# CITY OF ALBUQUERQUE

PLANNING DEPARTMENT – Development Review Services

November 1, 2013

Re: New Day Expansion – 2820 Ridgecrest S.E.  
Request for Permanent C.O. – **Accepted**  
Engineer's Stamp dated: 02-07-2013  
Certification dated: 10-29-13

Drawing file: FINAL / M18-D014_1949 CG-101 SIGNED 02-07-13.pdf

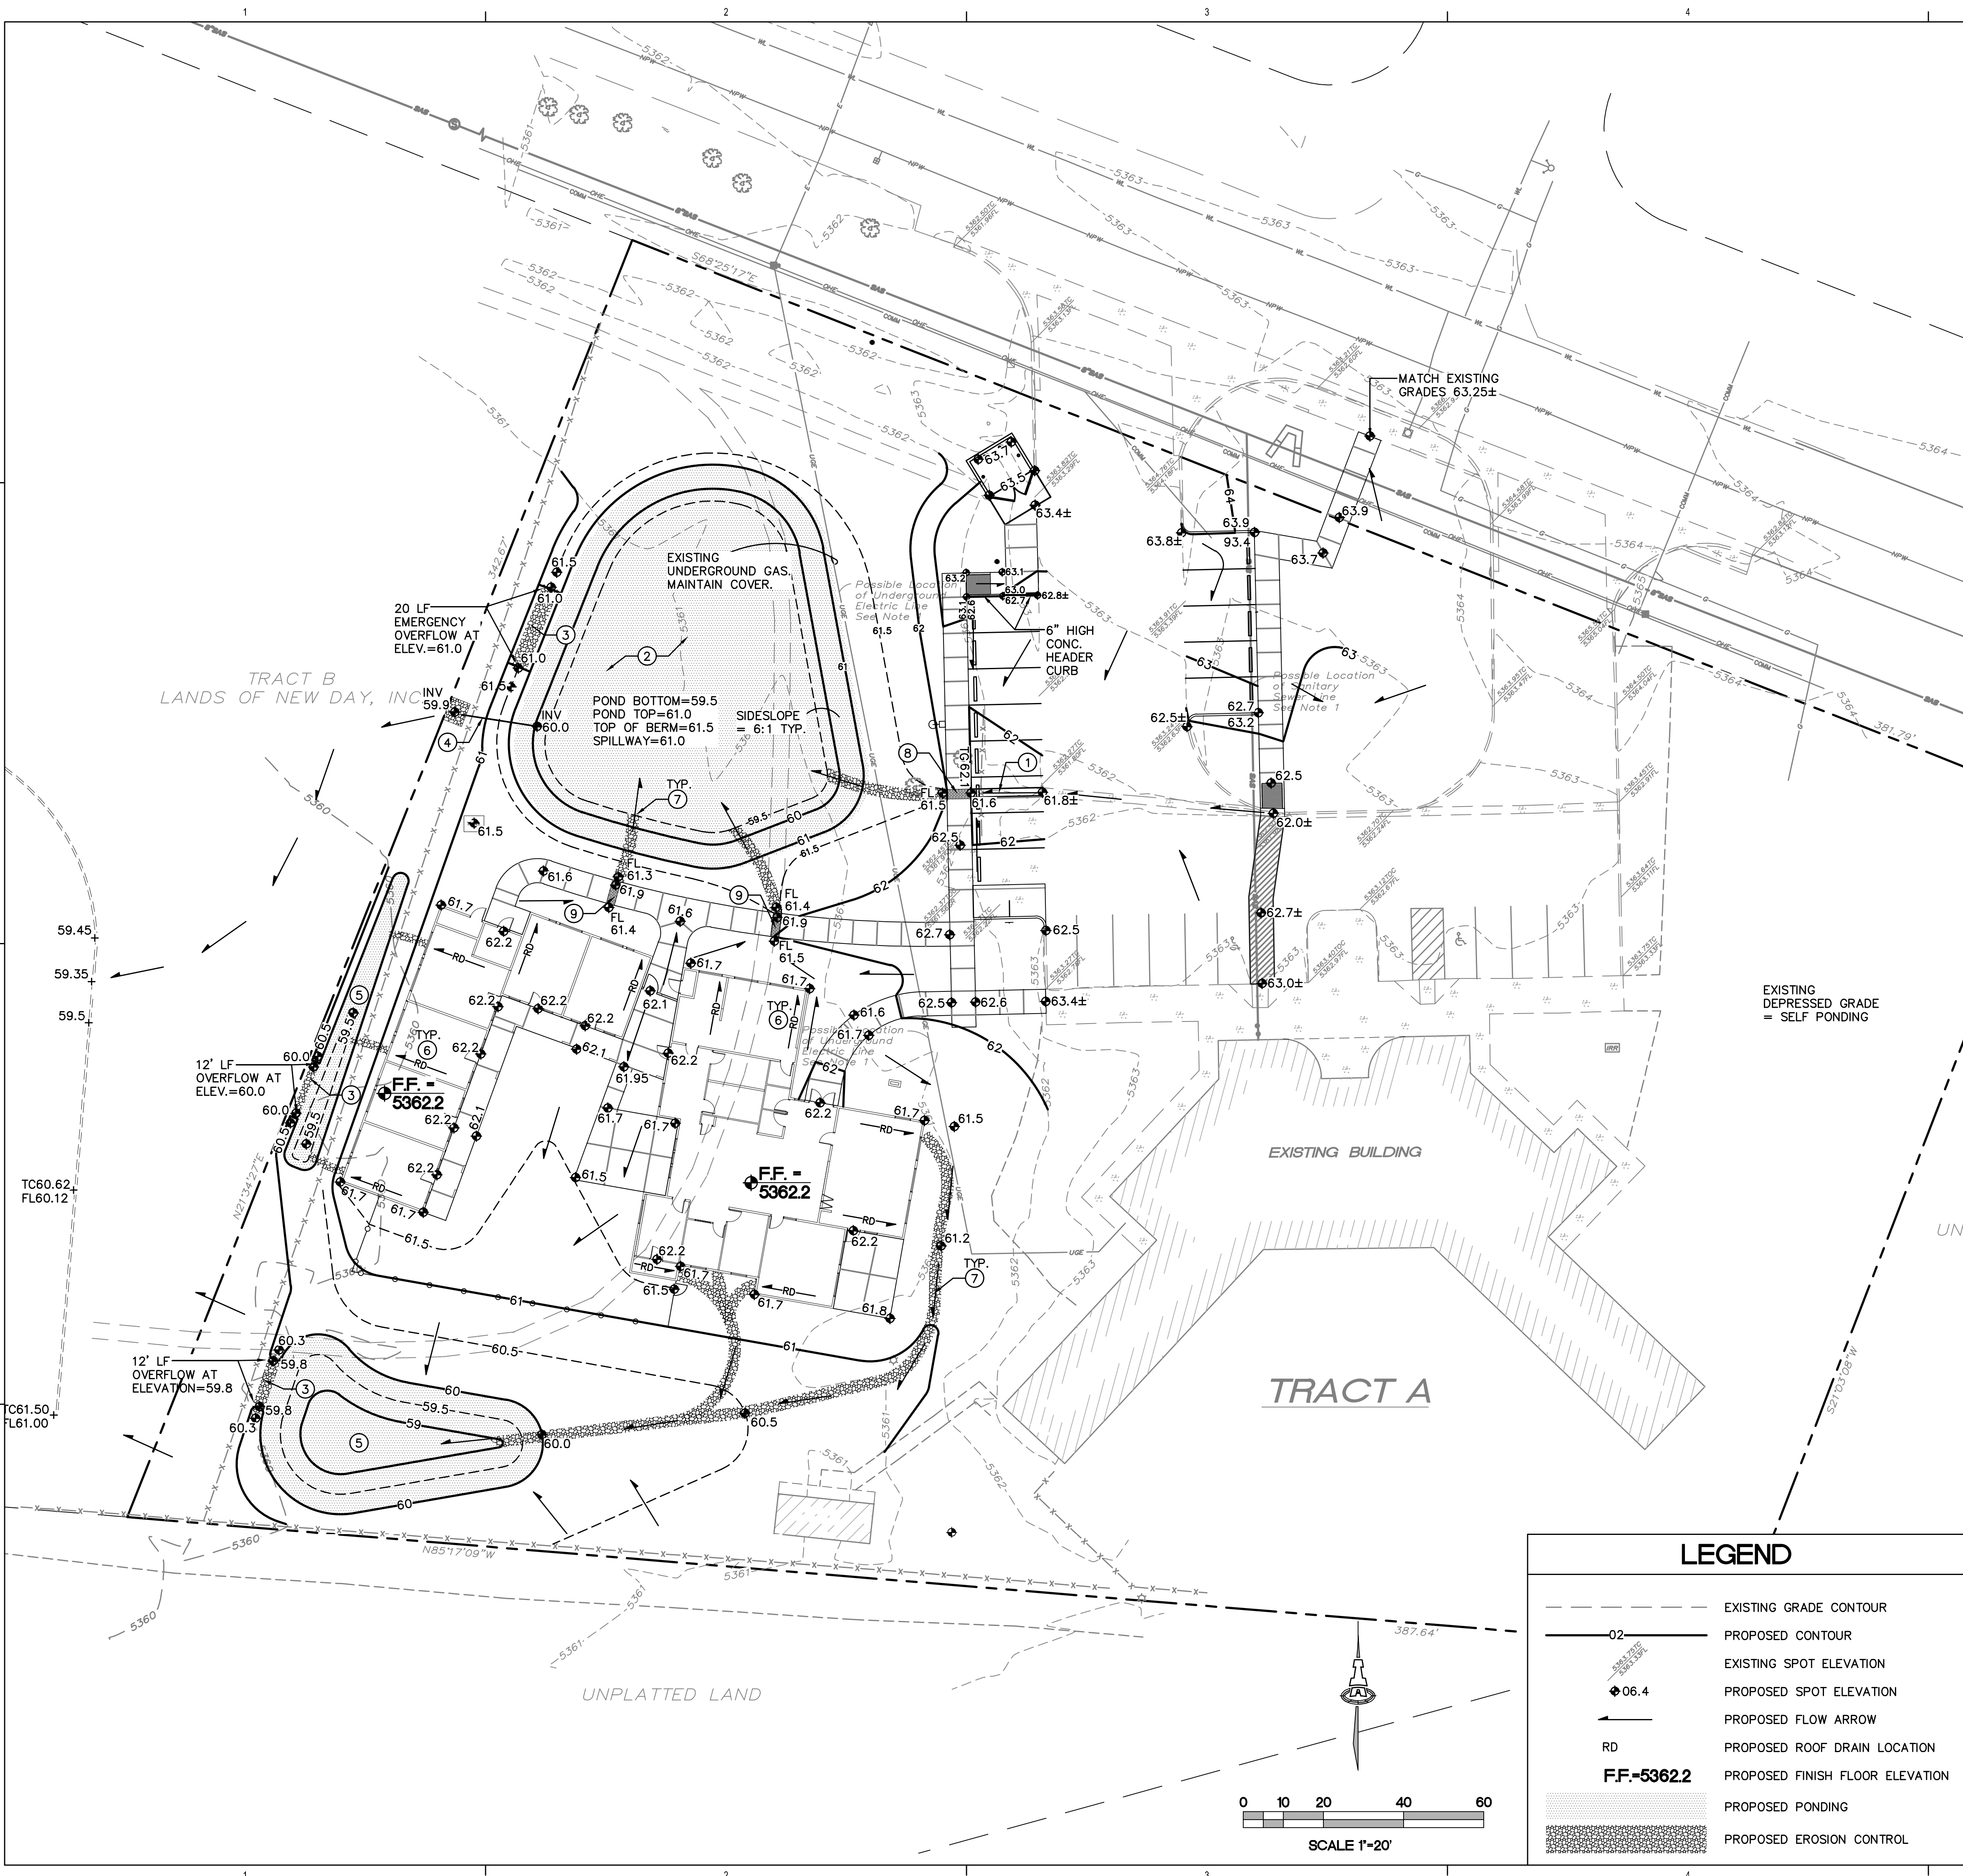
Based upon the information provided in your Certification received 10-01-2013, the above referenced Certification is NOT acceptable for a release of a Permanent Certificate of Occupancy by Hydrology. The information provided suggests deficiencies in the main, detention pond, and fails to document the required vs. As-Built detention pond volumes.

- ① Are FF Rock spillways in place  
 S. Pond: 12' x 6"  
 W. Pond: 12' x 6"  
 N. Pond: 20' x 6"
- ② Main Pond Bottom Too  
 High Ave. of Toe elev.  
 is 59.75 vs. 59.5 design
- ③ Main Pond spillway too LOW  
 60.81 Ave vs. 61.0 Design
- ④ Top of Pond N. of Spillway  
 is Lower than Spillway.

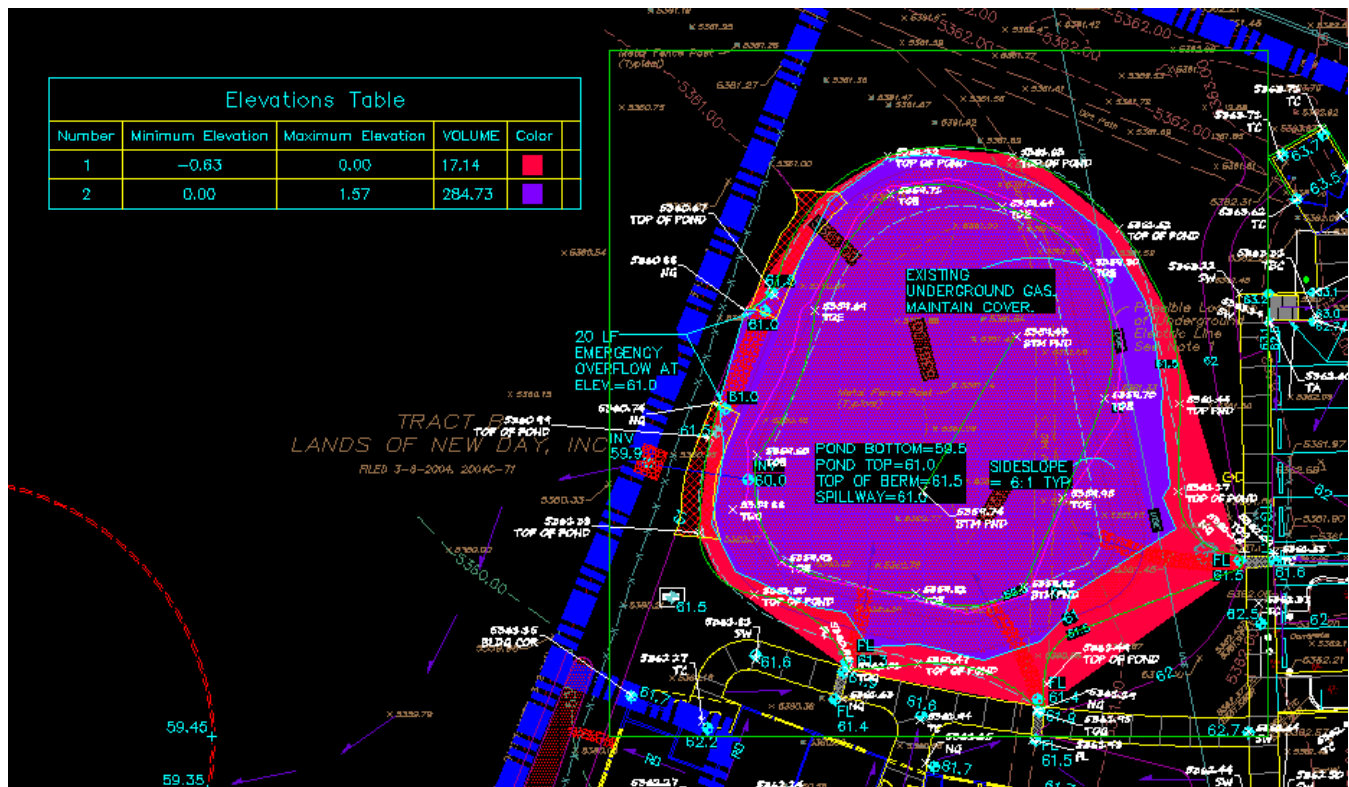
Based upon the information provided in your Certification received 10-30-2013, supplemented by the As-Built Pond Volume calculations you submitted today, the **above referenced Certification is acceptable for a release of a Permanent Certificate of Occupancy by Hydrology.**

Based on Civil 3D volume analysis using the as-built information provided by the surveyor, the as-built pond volume with a spillway elevation of 61.0 has an available volume of 285 CY = 7,695 CF (see image below) which exceeds the required volume.

The as-built pond has been constructed with a volume exceeding the required volume. In addition, excess volume is available for future construction. It should be noted that Basin 2 for this phase of construction, generates 6,203 CF. The pond design did not take into account the inflow / outflow hydrograph (0.8 cfs discharge rate from the pond).
